Your Ref :
Our Ref : A/61/17/NMA

Section 96A of the Town & Country Planning Act 1990 (as amended)
Town and Country Planning (Development Management Procedure) (England) Order 2015 (as amended) - Article 10

Application for a non-material amendment following a grant of planning permission A/182/16/PL relating to first floor level change from tile hanging to render with feature timbers (Plot 1) Ham Manor Estate, West Drive, Angmering,

DRAWING TITLE
Plot1
Proposed plans and elevations

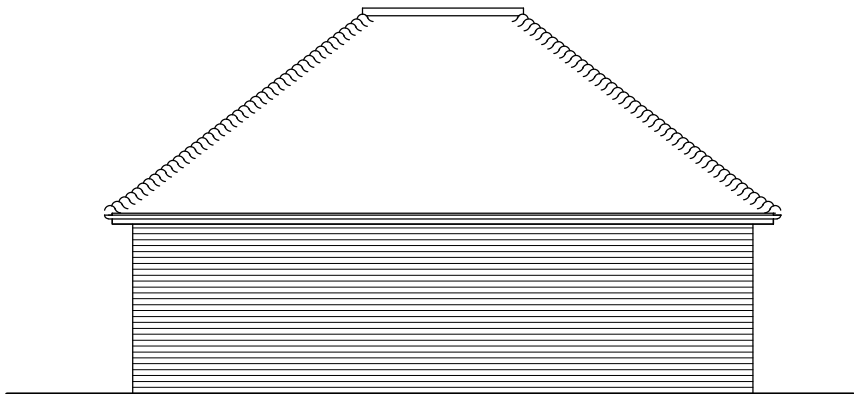
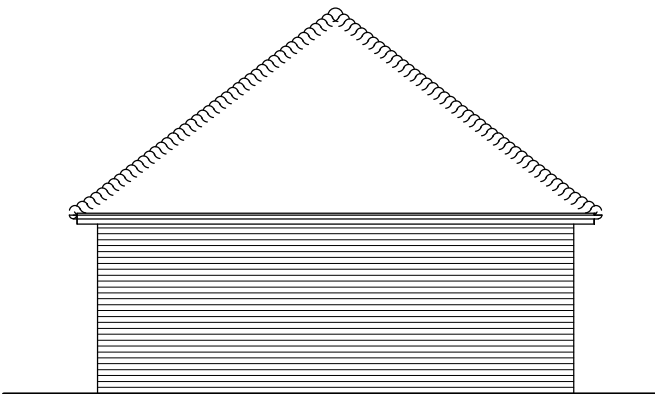
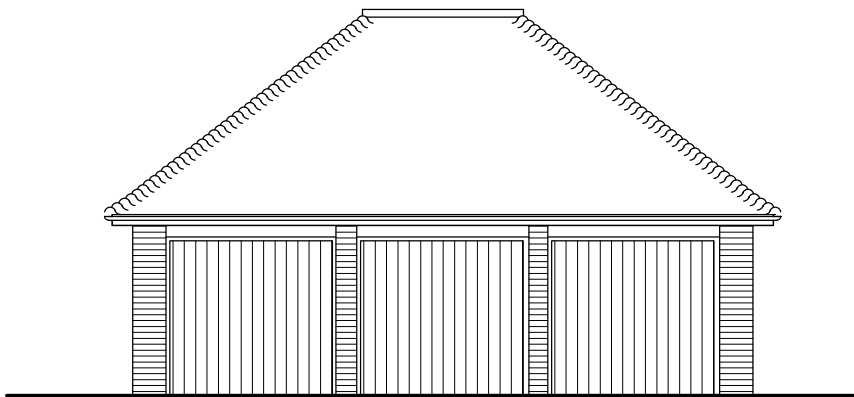
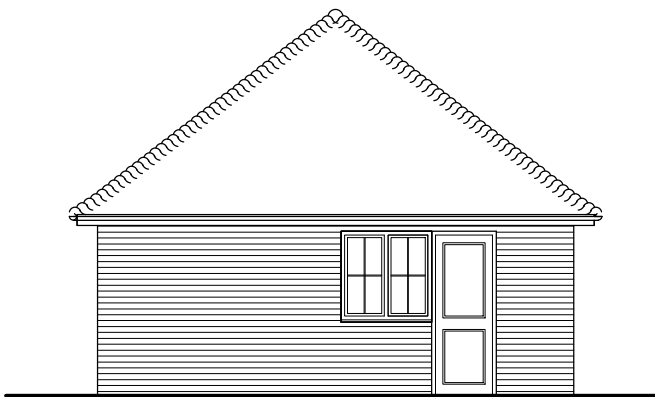
I refer to your recent application for a Non Material Amendment. From the information submitted I am able to take the change in the materials at first floor of Plot 1 from tile hanging to render with feature timbers as a Non Material Amendment to A/182/16/PL.

Please note that drawing 2.02 A ' Plot 1 proposed plans and elevations' has therefore become the approved plan for planning permission A/182/16/PL in relation to Plot 1 .
